City of Albuquerque Stormwater Construction Site Inspection Report

General Information						
Project Name:	Chick-fil-A					
Location:	4001 Coors Blvd NE					
Site Contact Name & Agency	Don Ikeler 404-305-4407	ESC File No.	G11E069C			
	Chick-fil-A	NPDES Id. No.	NMR1002EH			
Inspection Date:	10/16/19	Start/End Time:	4:40/4:55PM			
CoA Stormwater Inspector:			Doug Hughes			
Construction Phase:	Pad overexcavation					
Type of Inspection:	Regular	Storm Event	Post Storm Event >0.25"	311/Complaint	Follow Up

SHEET TITLE  
EROSION  
CONTROL PLAN

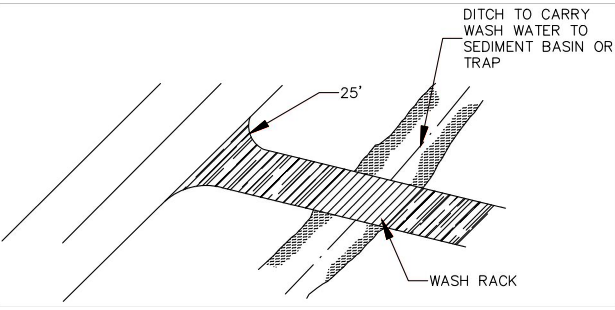
Item Number	Deficiency/ Corrective Action		
	Post a notice of your permit coverage		
	self inspection reports required every 14 days and after each rain>0.25". Please e-mail		
	Maintain stormwater controls (BMPs). Silt fence needs repaired east side.		
	Keep construction and domestic waste container lids closed when not in use.		
2.1	Discharge off site? (Y/N)	No	
4	Self Inspection Reports		Latest report Date: n/a
